Our Ref: Y/37/26/NMA

**Section 96A of the Town & Country Planning Act 1990 (as amended)
Town and Country Planning (Development Management Procedure) (England) Order 2015
(as amended) - Article 10**

Non material amendment following the grant of Y/53/25/HH for proposed widening and change from pitch to flat roof to single storey rear extension.

Flints Hoe Lane Flansham PO22 8NP

Proposed Extensions and Alterations
Plans and Elevations
Planning

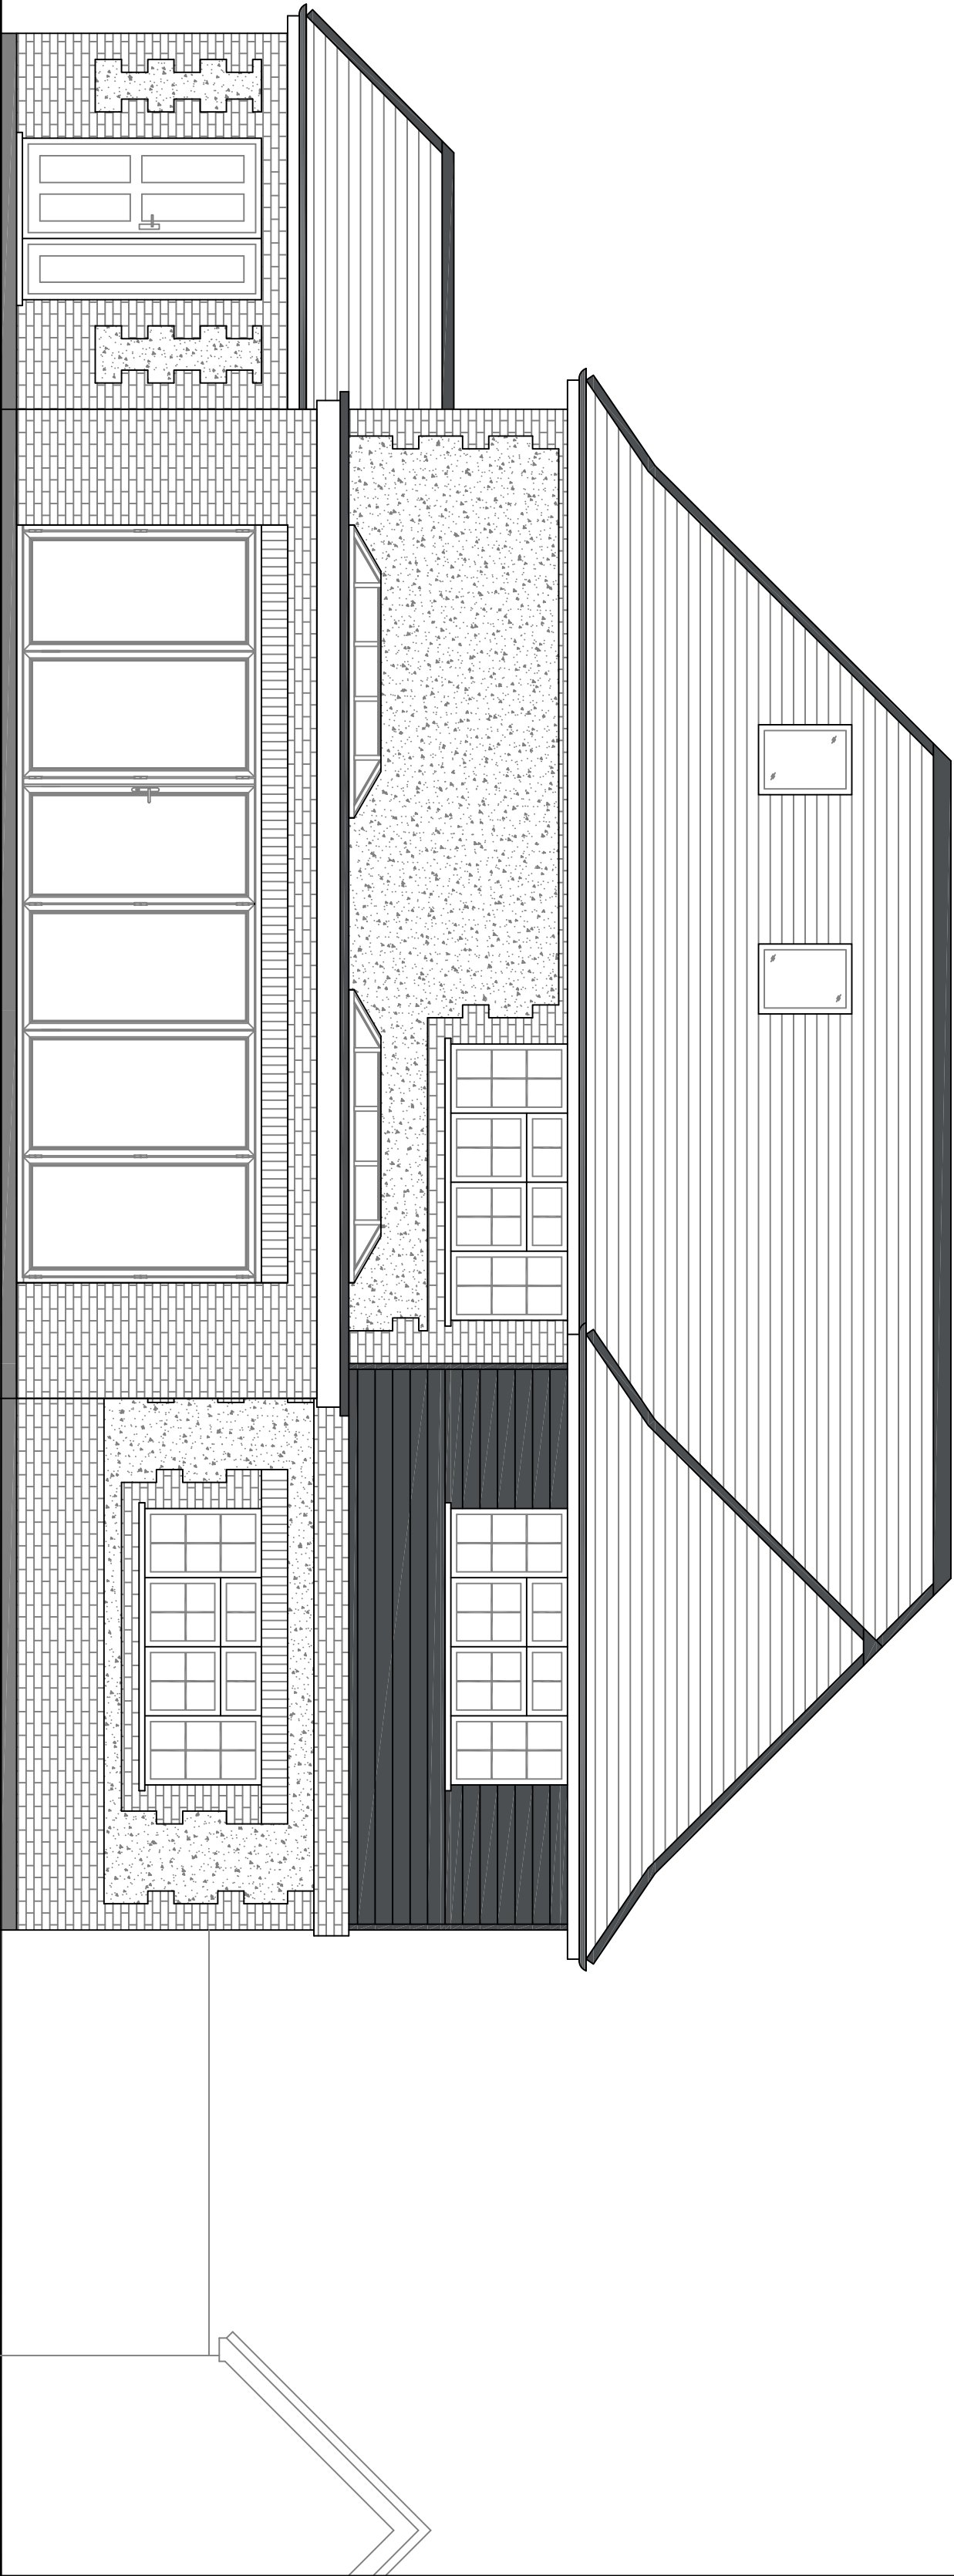
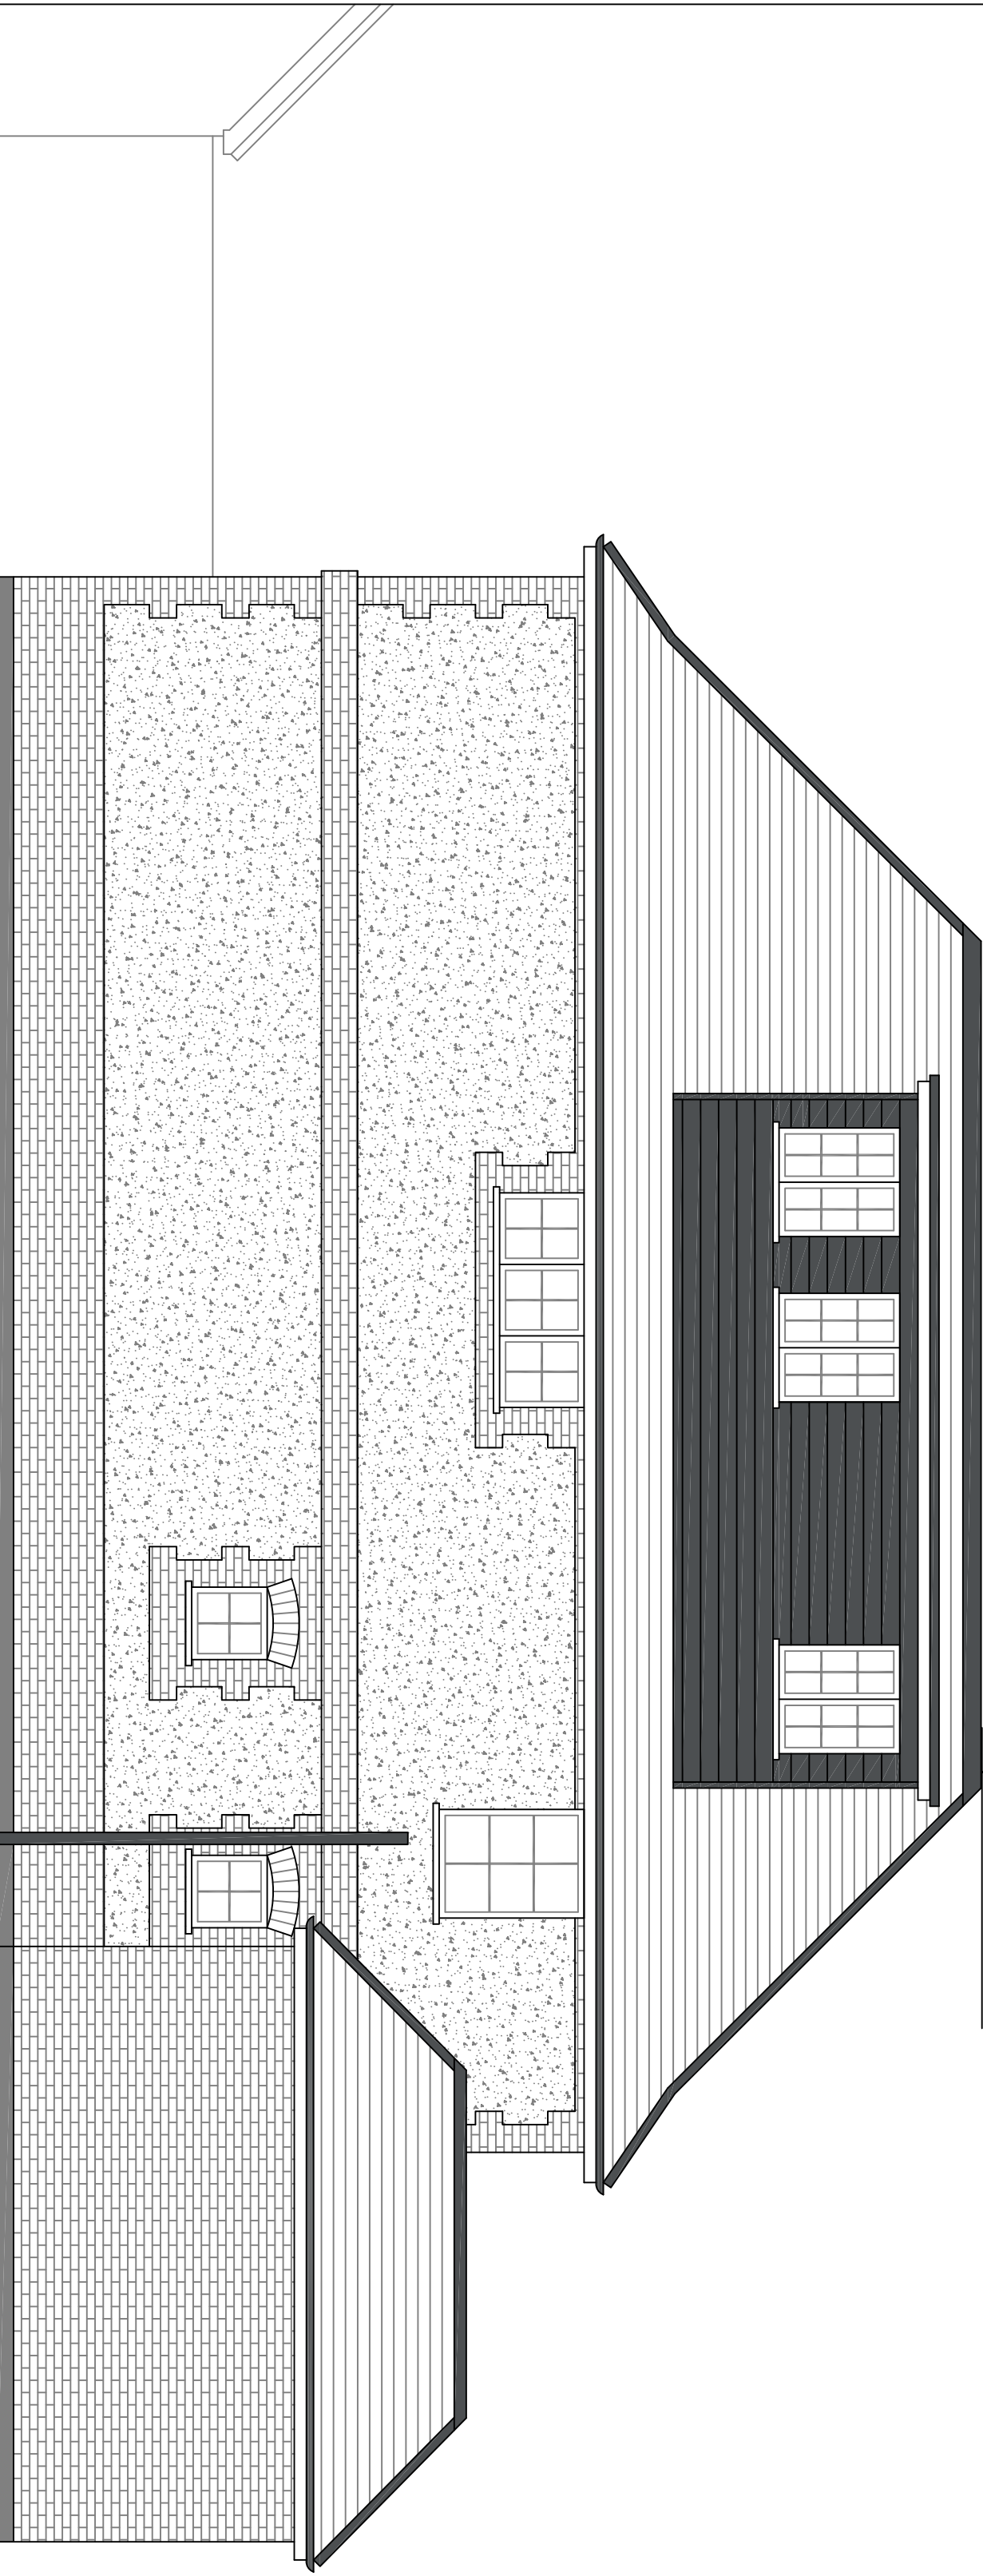
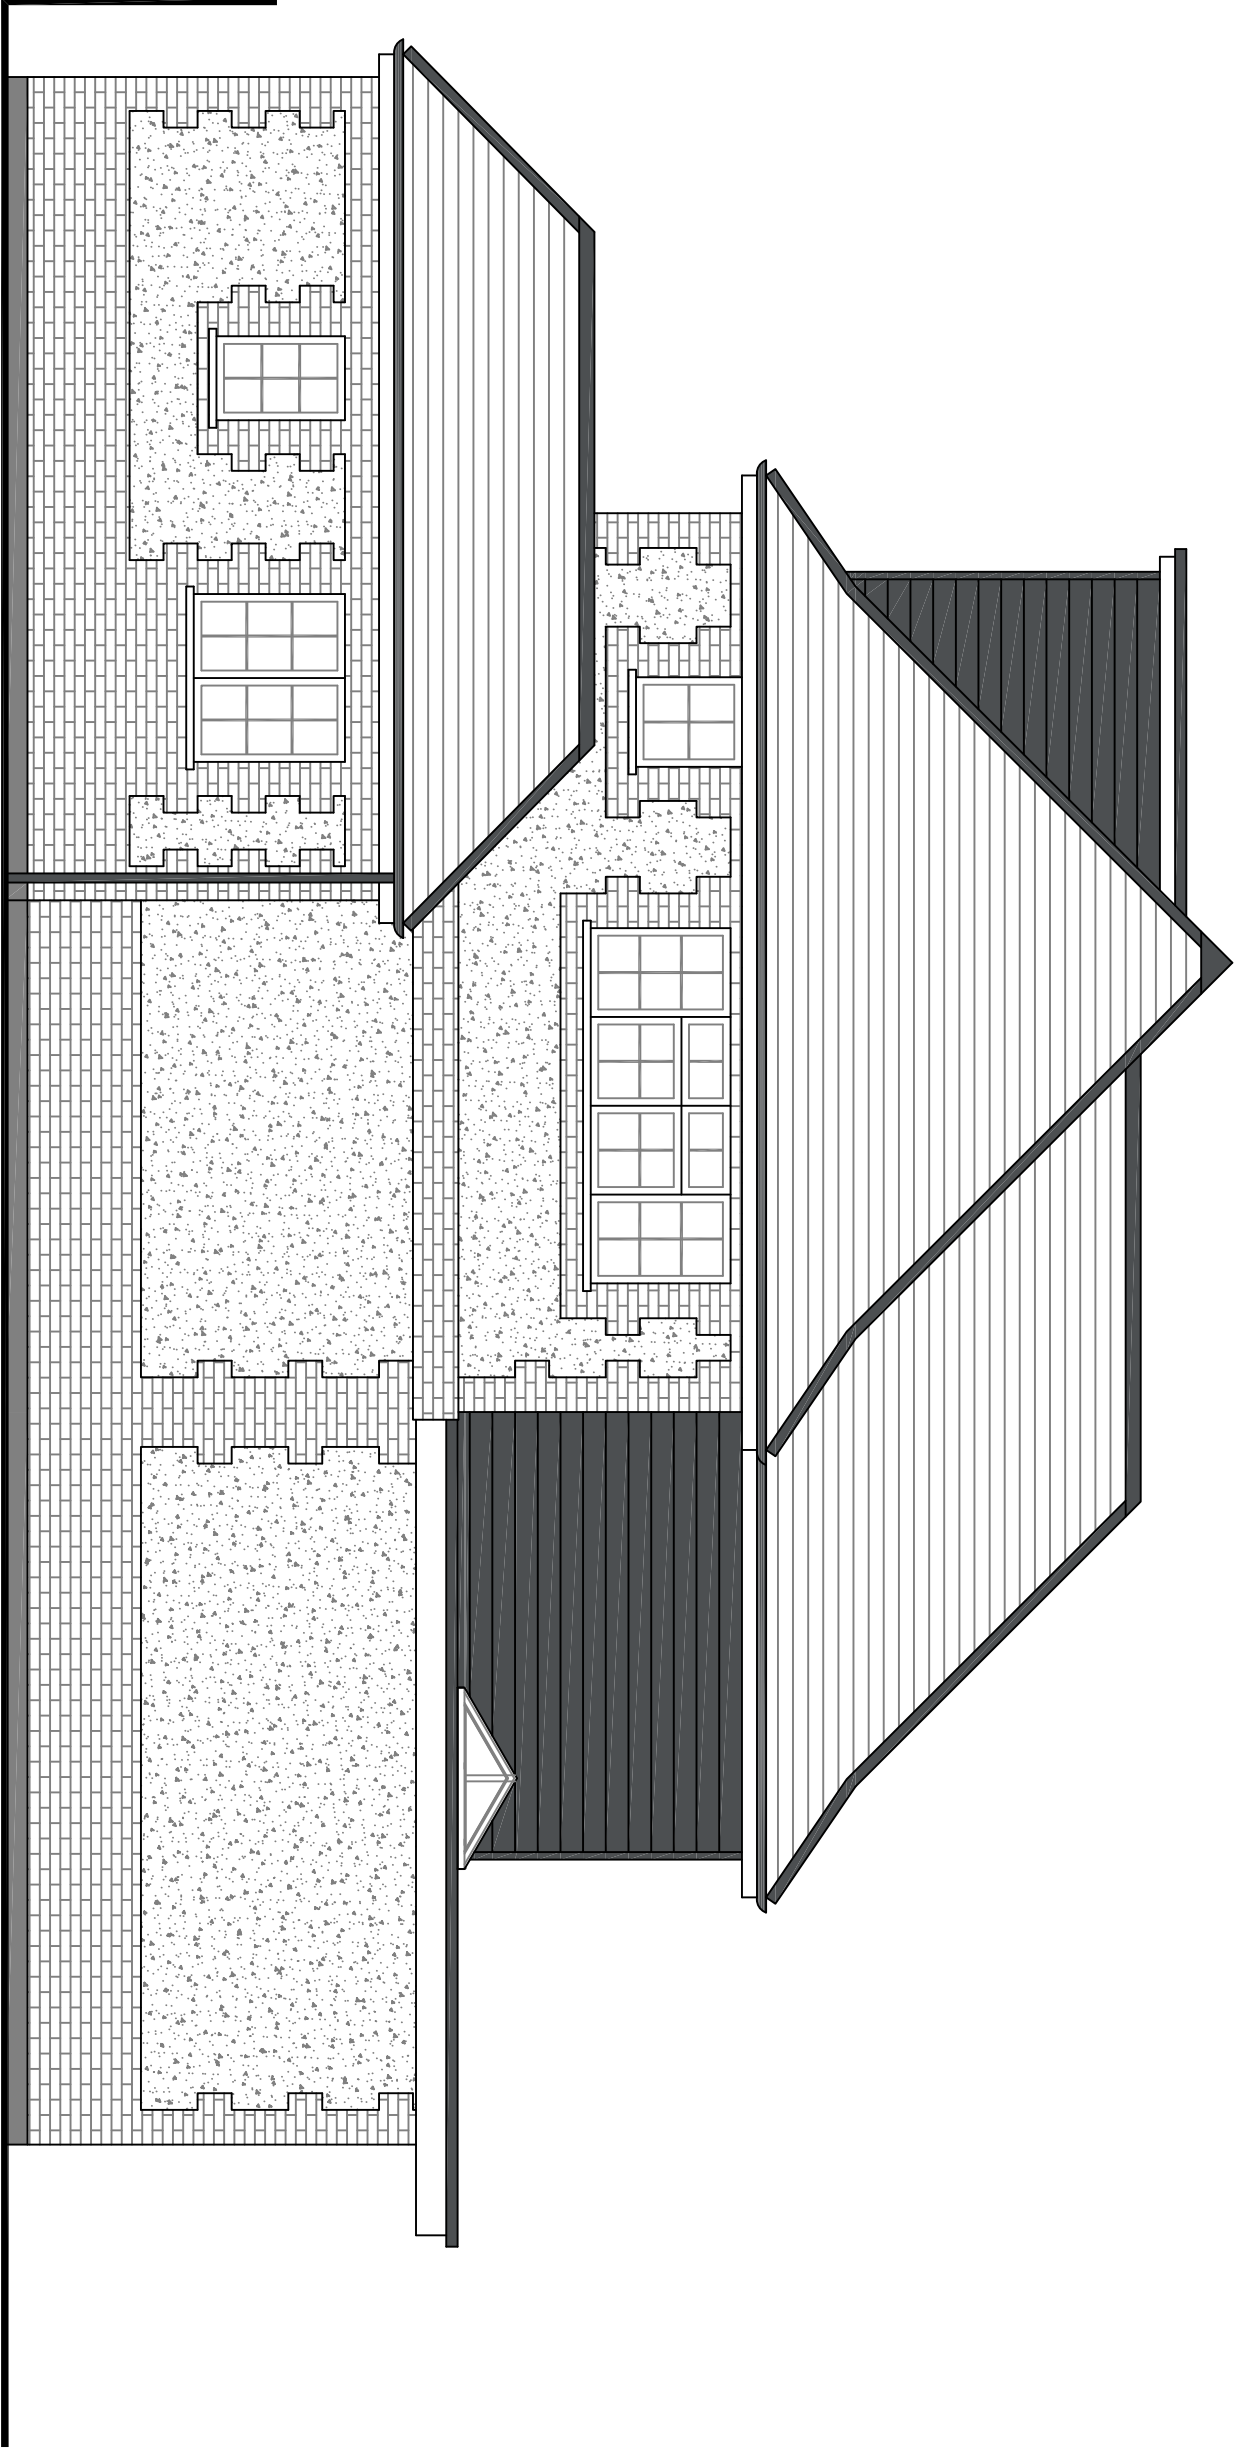
The reason that this proposal has not been accepted as a Non-Material Amendment is because it would result in a significant increase in width, and as such would result in a materially different appearance to that previously approved. It cannot therefore be considered under section 96A of the Town and Country Planning Act 1990.
